About the application

Application number: 2020/94268	
What is the application for?:	Erection of two storey side and single storey rear extensions and boundary wall
Address of the site or building:	132, South View Road, East Bierley, BD4 6PJ
Postcode:	BD4 6PJ

Status	PRELIMINARY
Client	EMMA SIMPSON
Site Address	132 SOUTH VIEW ROAD, EAST BIERLEY, BD4 6PJ
Project	EAST BIERLEY EXTENSION
Job Type	HOUSEHOLDER APPLICATION
Title	SIDE & REAR EXTENSION
Scale	VARIOUS
Date	04/12/2020
Drawing No:	CSAD202010-04

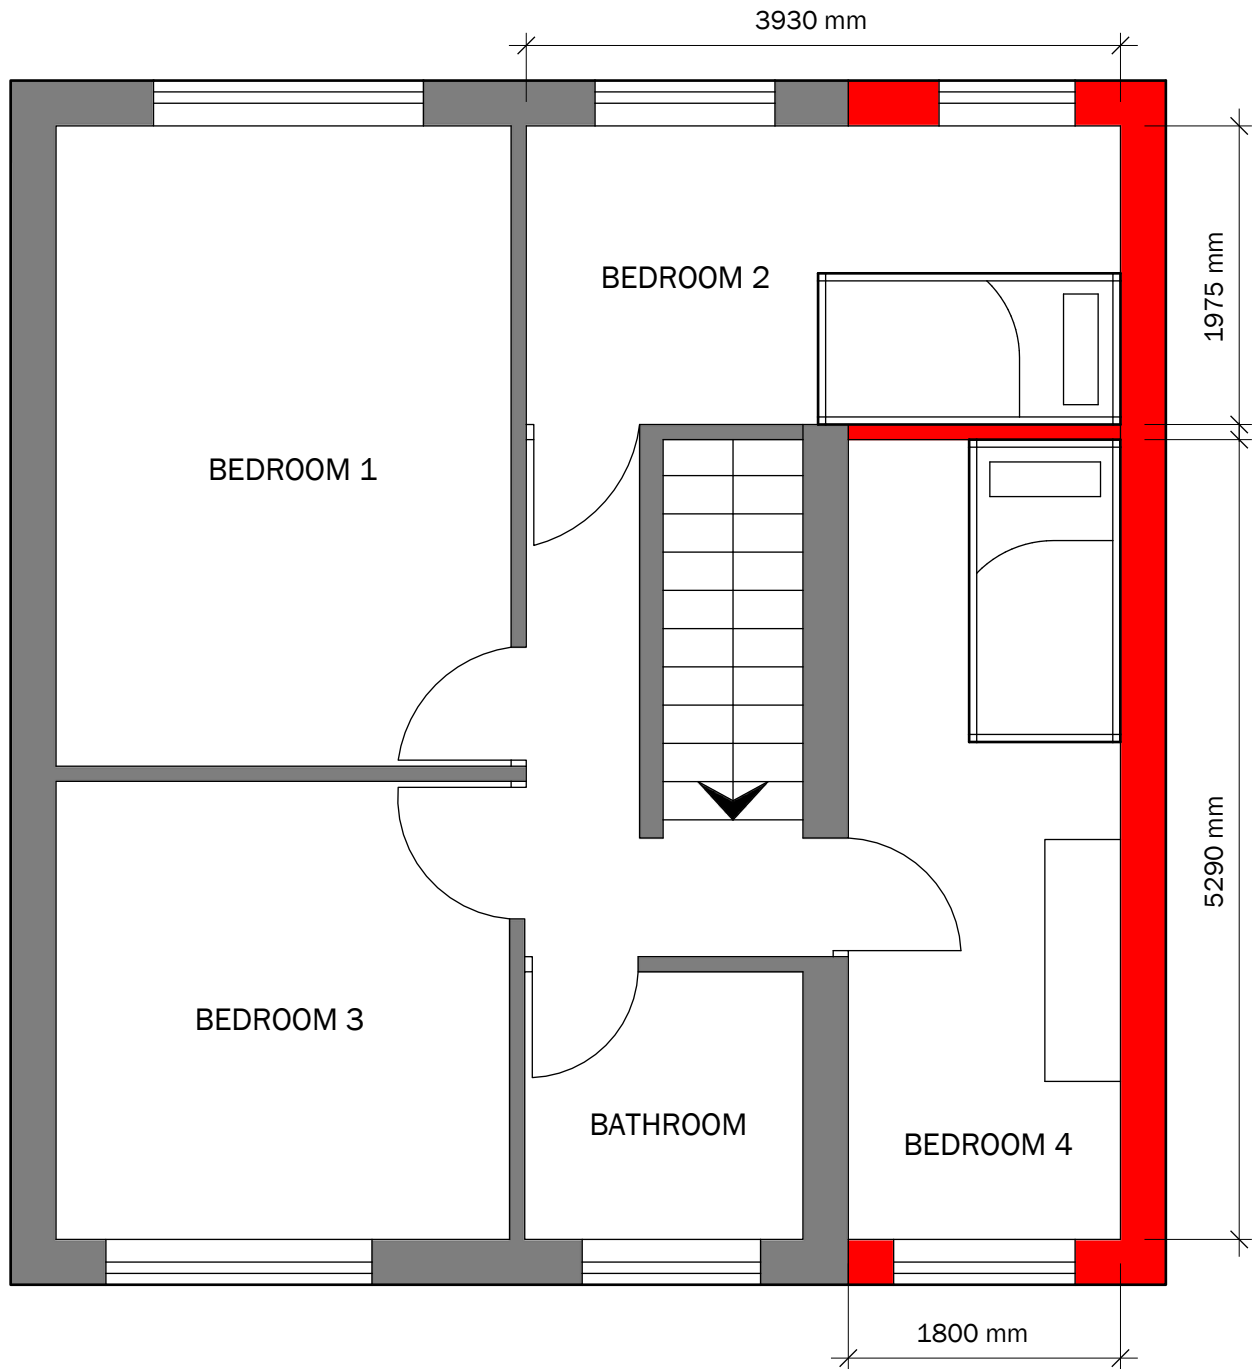
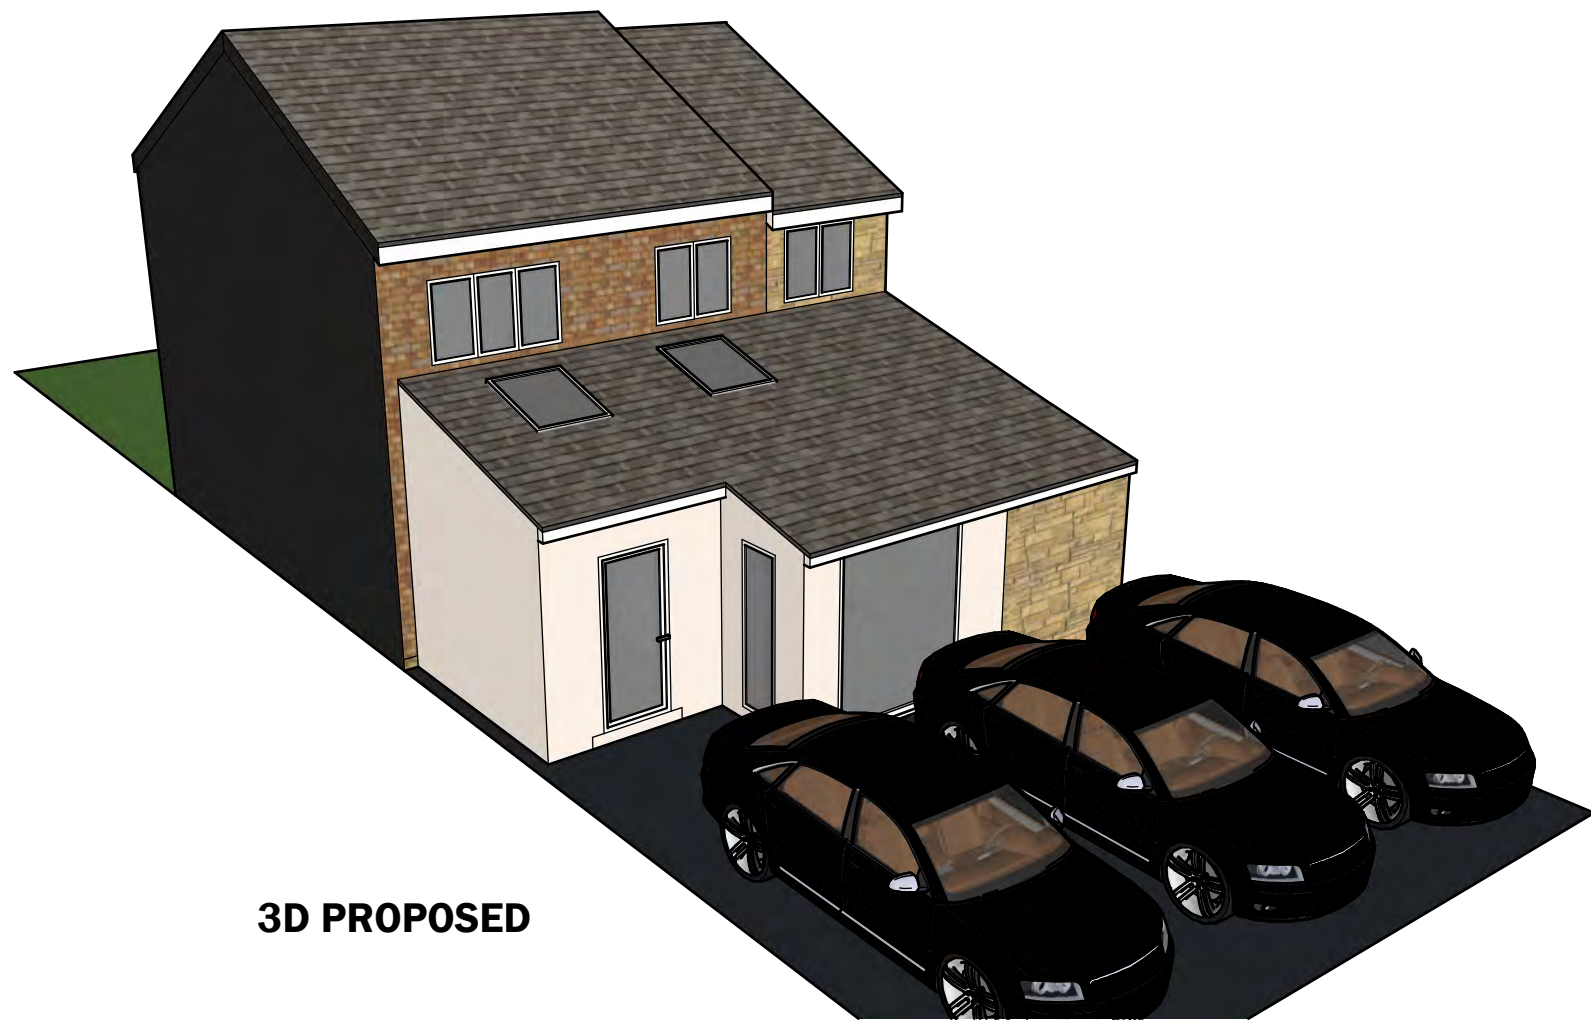
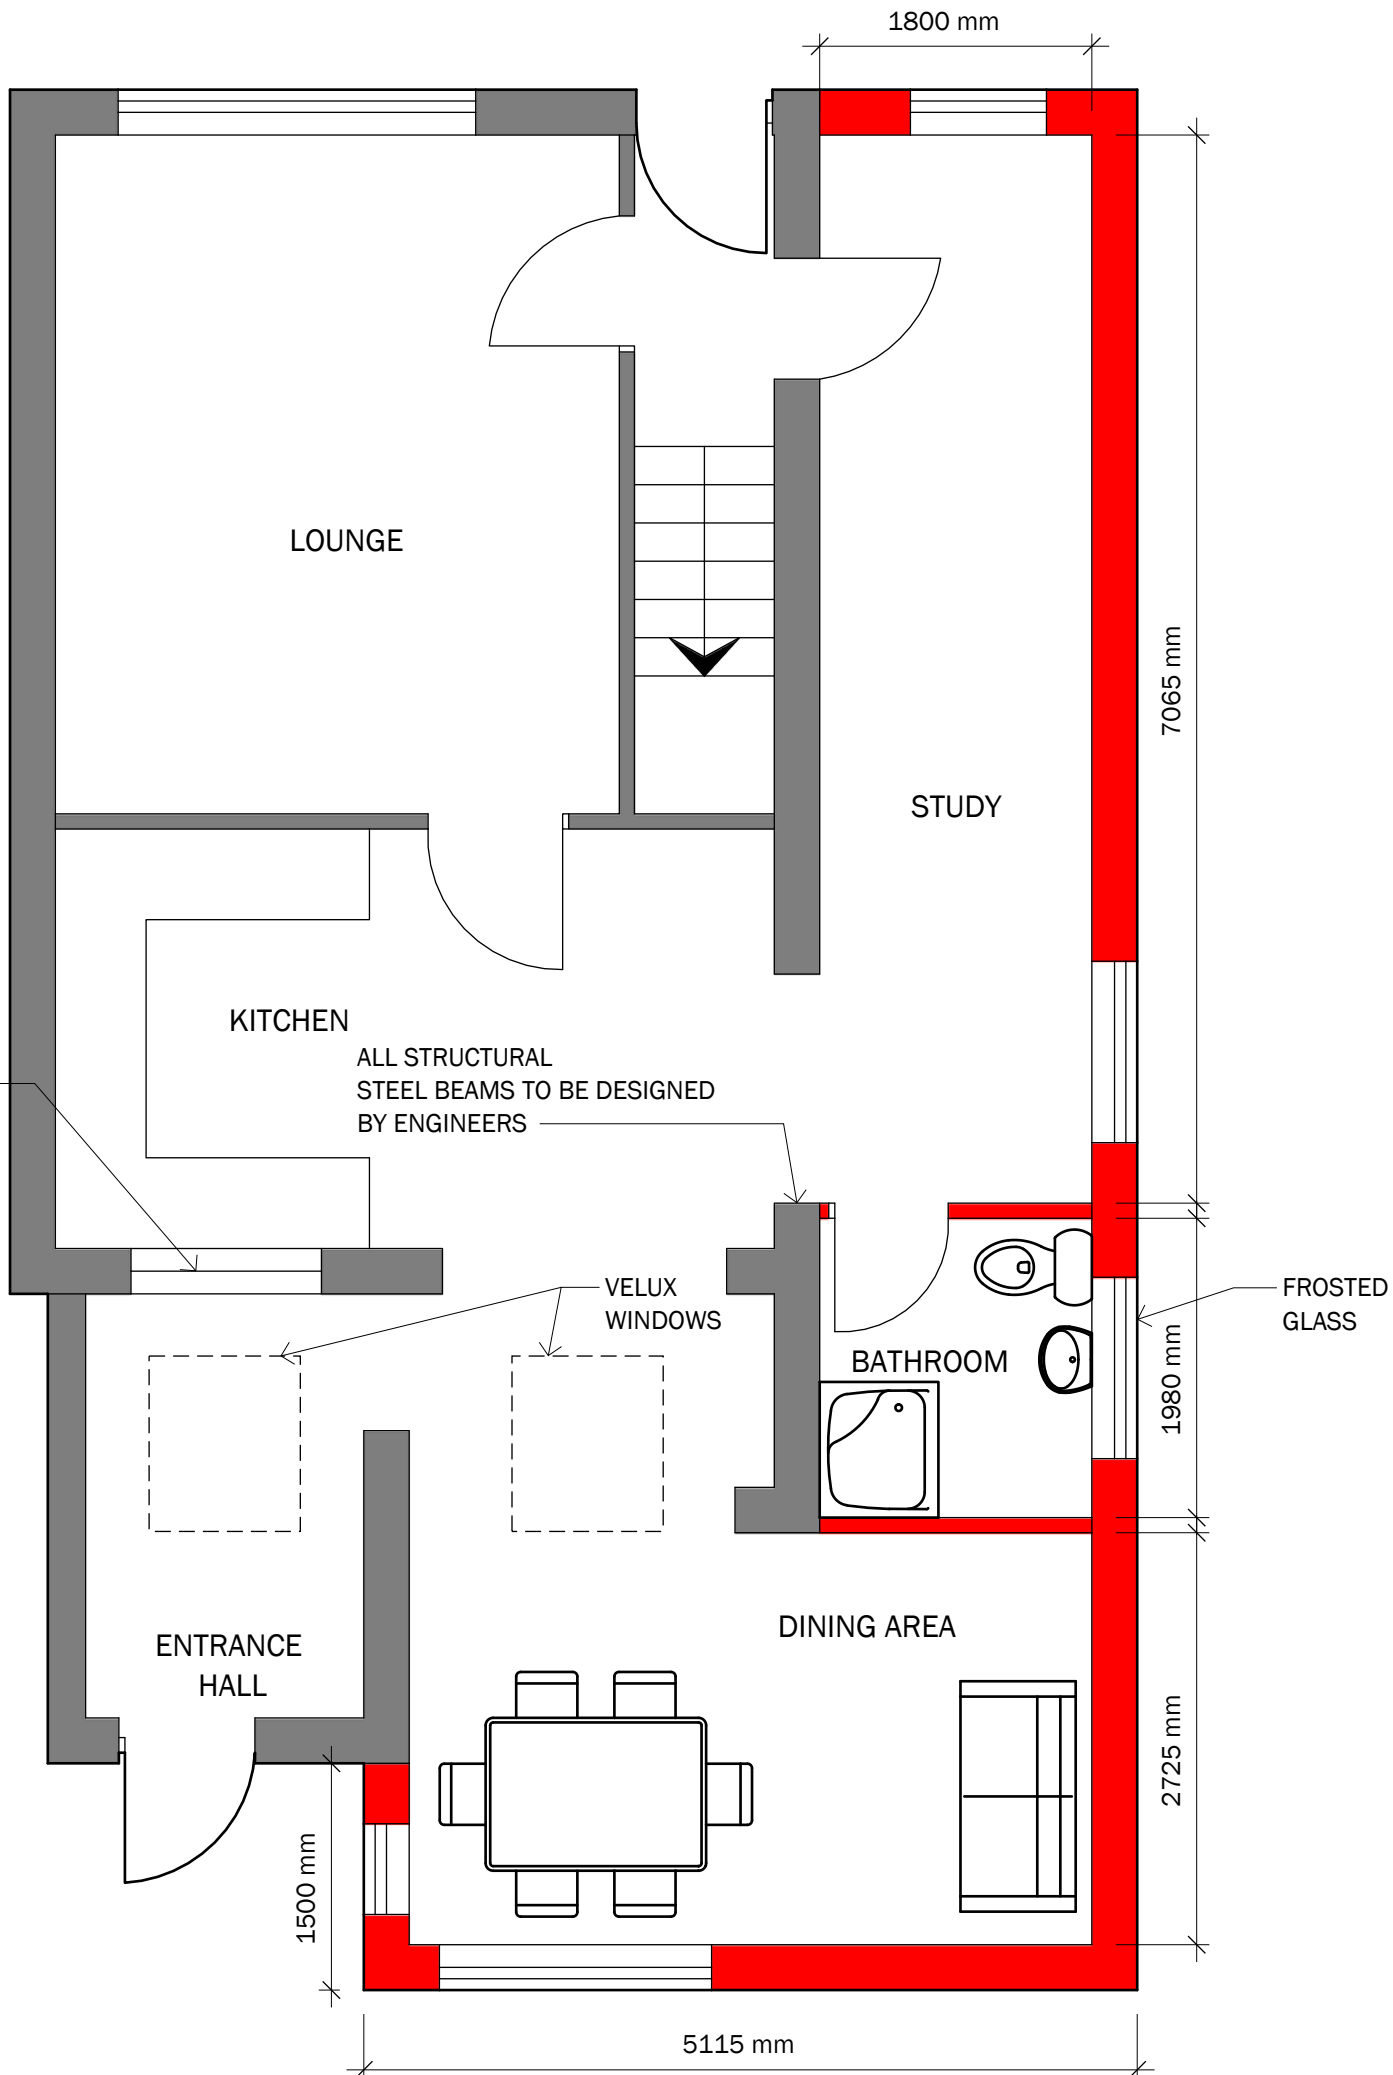
Type of comment: An objection	
Do you wish your comments to be published on the website anonymously?	Yes
After viewing the application, including plans, I would like to object to the current application for the proposed extension to 132 South View Road, East Bierley, BD4 6PJ The height, size and closeness to my house would severely reduce the light to my home, in particular the landing (just one window and directly underneath is the docking station for my stairlift which I need to be able to see to get on). Bathroom (one window being the only source of daylight). Kitchen (as the extra building and added length will restrict the light there is and will overlook my kitchen and paved seating area). My main concern is the loss of privacy and loss of light. There are no specific measurements (on the plans) from the external wall of the extension to my drystone boundary walls but it looks extremely close. My house is very close to my drystone boundary wall (under one metre) The other concern is for the drystone boundary wall itself (part of which is the external wall of my old cottage). It is about 300 years old. I am concerned that any development too close to the wall will damage it. I am also worried about the need to maintain both walls and that there would not be enough space I do not object to the proposal to build a boundary wall in front of 132 South View Road
